Submission Form

Epping to Thornleigh Third Track Proposal. Application number SSI 5132.

Figure S.6 Cross-section and elevation - New Cheltenham Station concourse building (see also S.5 for artist's impression)

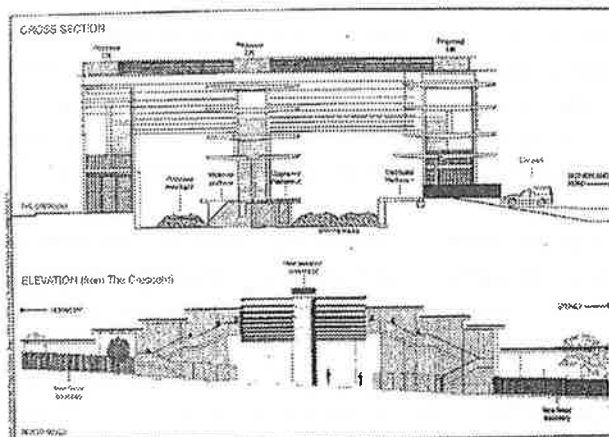
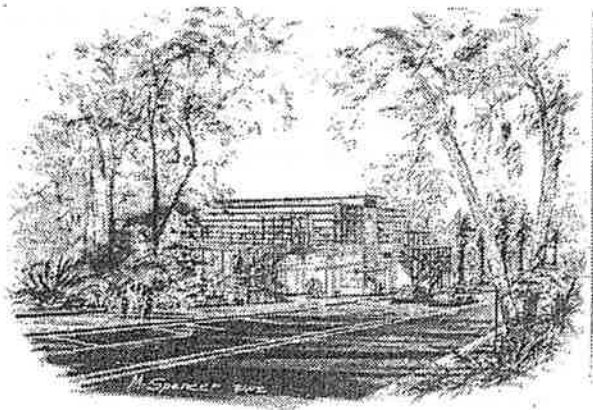
- The proposed redevelopment of Cheltenham Station shows no regard for the HCA. The visual impact of the proposed 13m high glass and steel concourse is totally unacceptable in this HCA.

Figure 5.3 Future Cheltenham Station layout

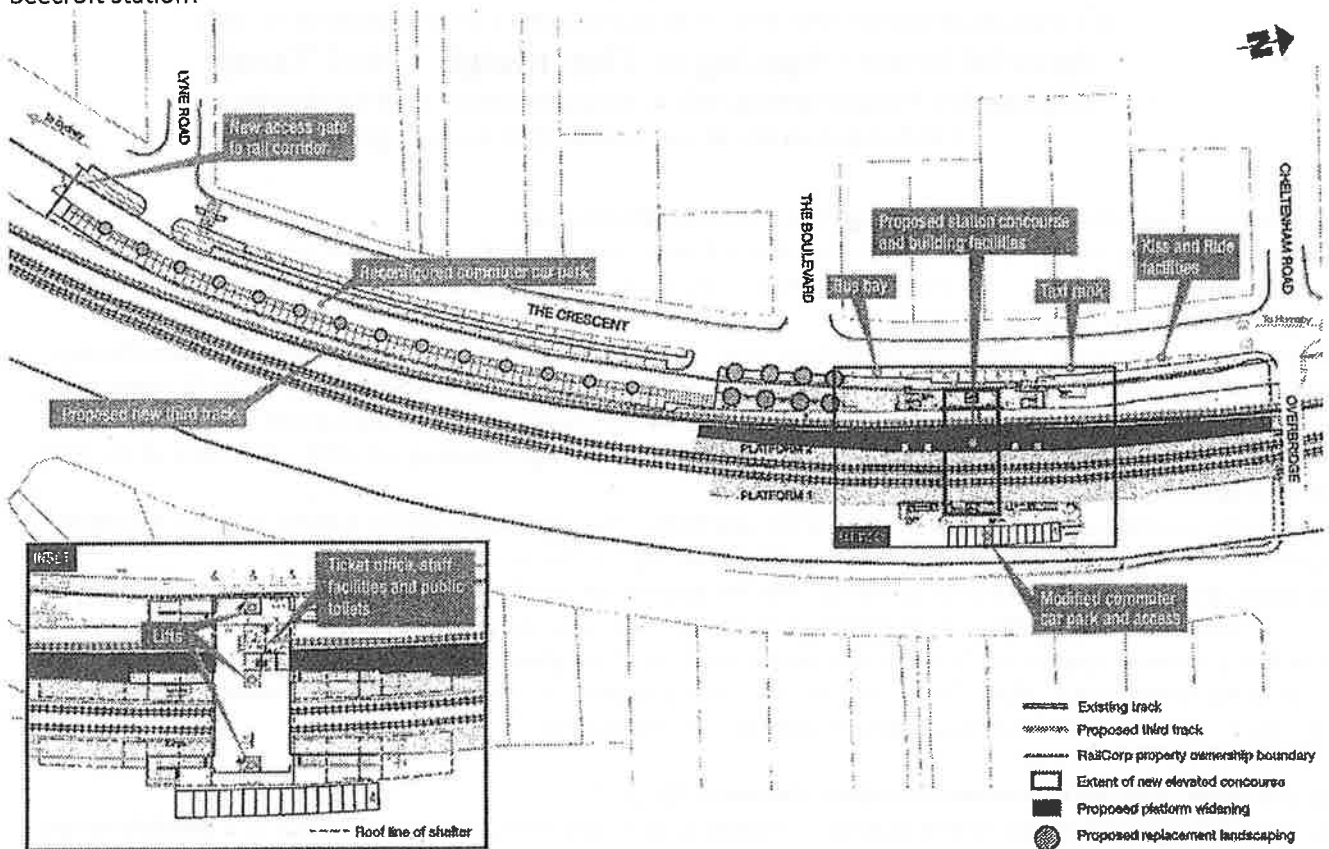
- There has been inadequate assessment of the project's impact on the fabric of the Beecroft Cheltenham Heritage Conservation Area (HCA).
- The plan given for Beecroft Railway station Precinct is vague. The relationship to the trees, playground and original 1895 platform located south of the present station is not shown. A fourth track is shown on the eastern side. The plan does not include urgently needed lifts to allow disabled access at Beecroft Station.
